From: [REDACTED]
To: [REDACTED]
Subject: Ref: 23/02034/F Deposit
Date: 17 November 2023 10:37:28
Attachments: [REDACTED]

From: Borough Planning
Sent: 17 November 2023 10:36
To: [REDACTED]
Subject: Ref: 23/02034/F

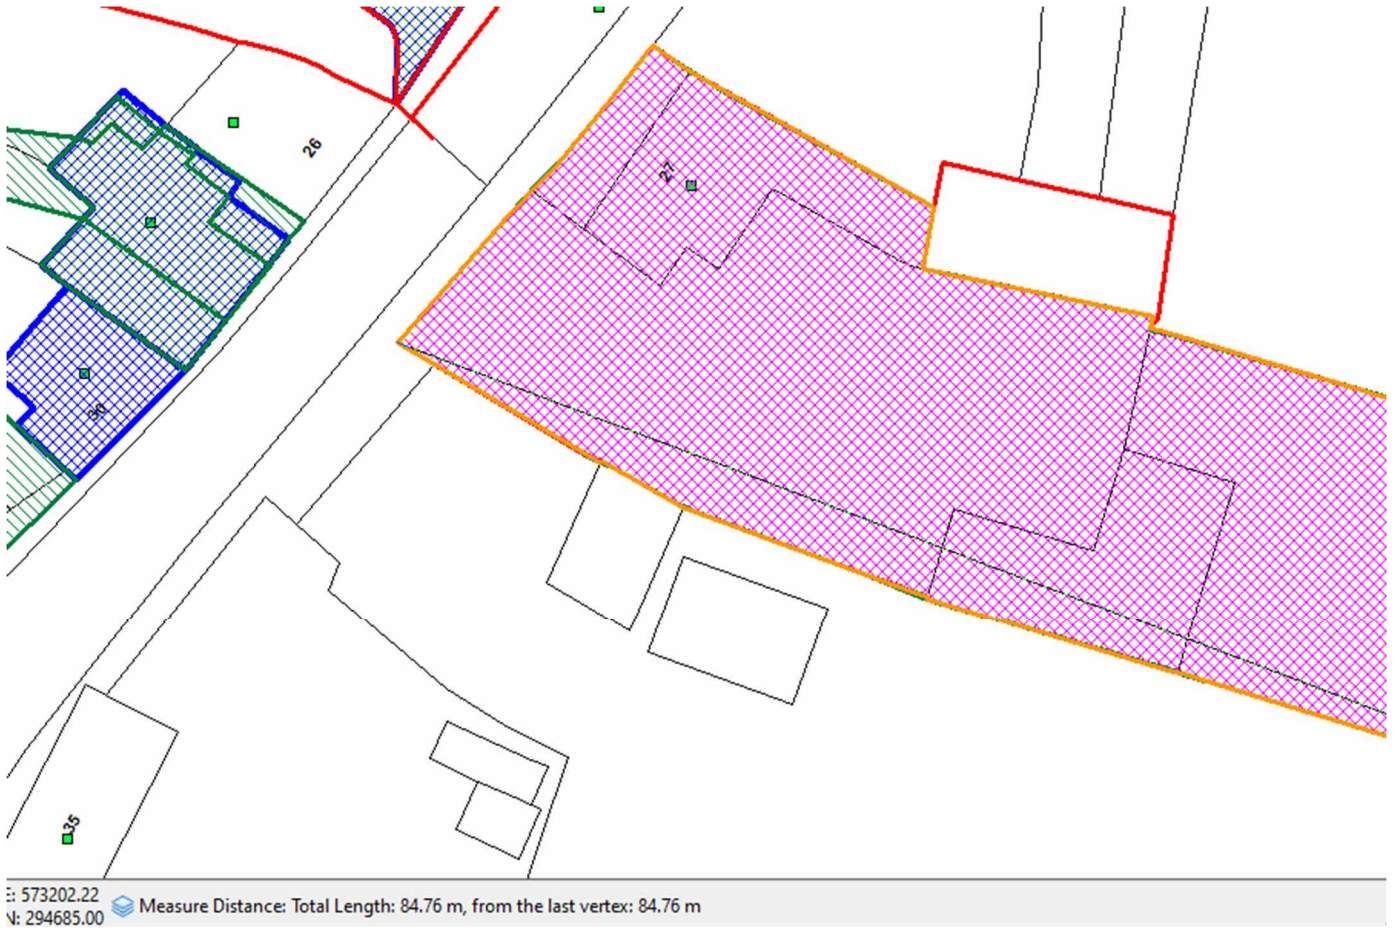
Here are the 2 plans regarding our previous telephone conversation. You can see in the grey box at the bottom of our plan that the length is 84.76m and the length on your plan is 76.25m. We measure the width to the left 23m, width to the right 20m and the top length 71m.
